## Application by One Earth Solar Farm Limited for One Earth Solar Farm

### The Examining Authority's written questions and requests for information (ExQ1)

Issued on 7 August 2025

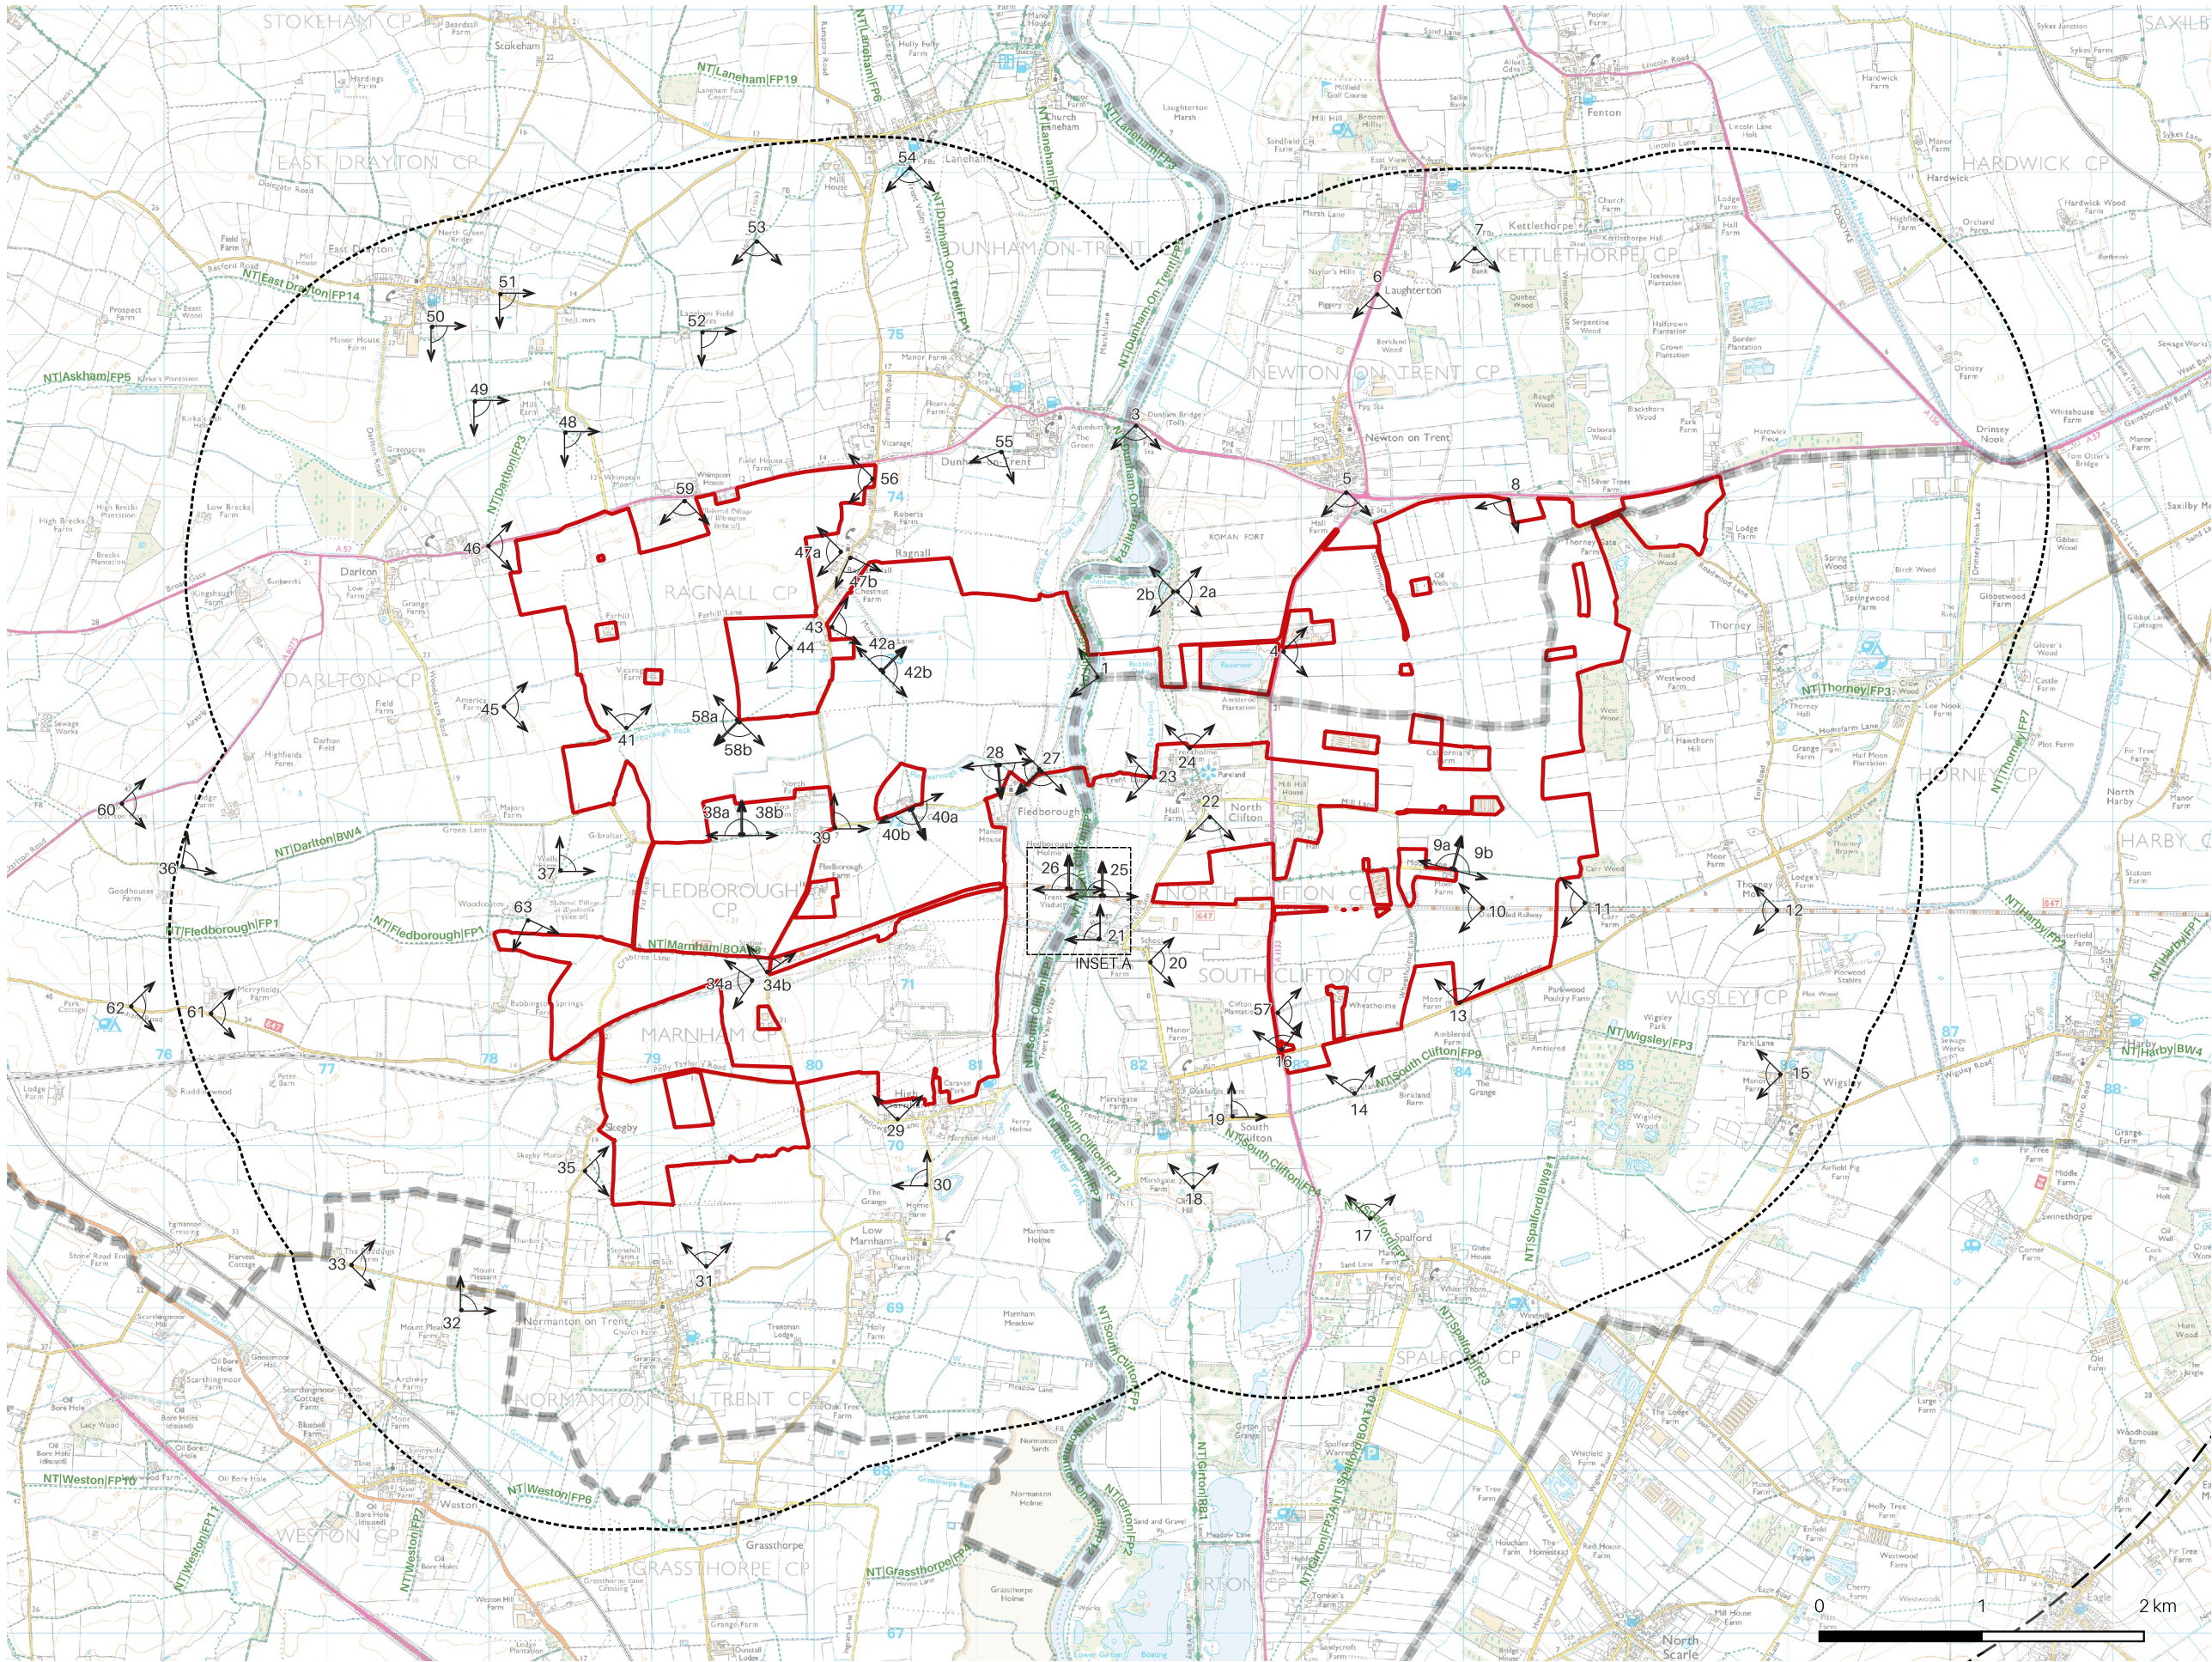
Q1.0.10	The Applicant	<p><b>Locations of Photographs</b></p> <p>In ES Vol 3 Figures 11.1-11.14 – Part 16 The Viewpoint locations appear to be slightly different locations from the versions provided elsewhere, please explain the discrepancy.</p>
Q1.0.11	The Applicant	<p><b>Residential Receptors</b></p> <p>(1) Table 11.10 on page 70 of ES Chapter 11 identifies a series of residential receptors, (Figure 13.2 identifies residential receptors R1-R10, for the Air Quality Chapter) please advise where a similar plan can be found identifying these receptors in respect of the landscape chapter?</p> <p>The ExA note there is additional detail provided in the D1 response with a series of sheets described as 'Residential assessment and design response'.</p> <p>We have not located a table or plan which identifies the residential receptors. If there is not one, please provide one, or advise us where it can be found.</p> <p>In the absence of a plan clearly identifying individual residential receptors, please set out how you have undertaken an individual assessment for each residential property in either landscape, amenity or health terms.</p>
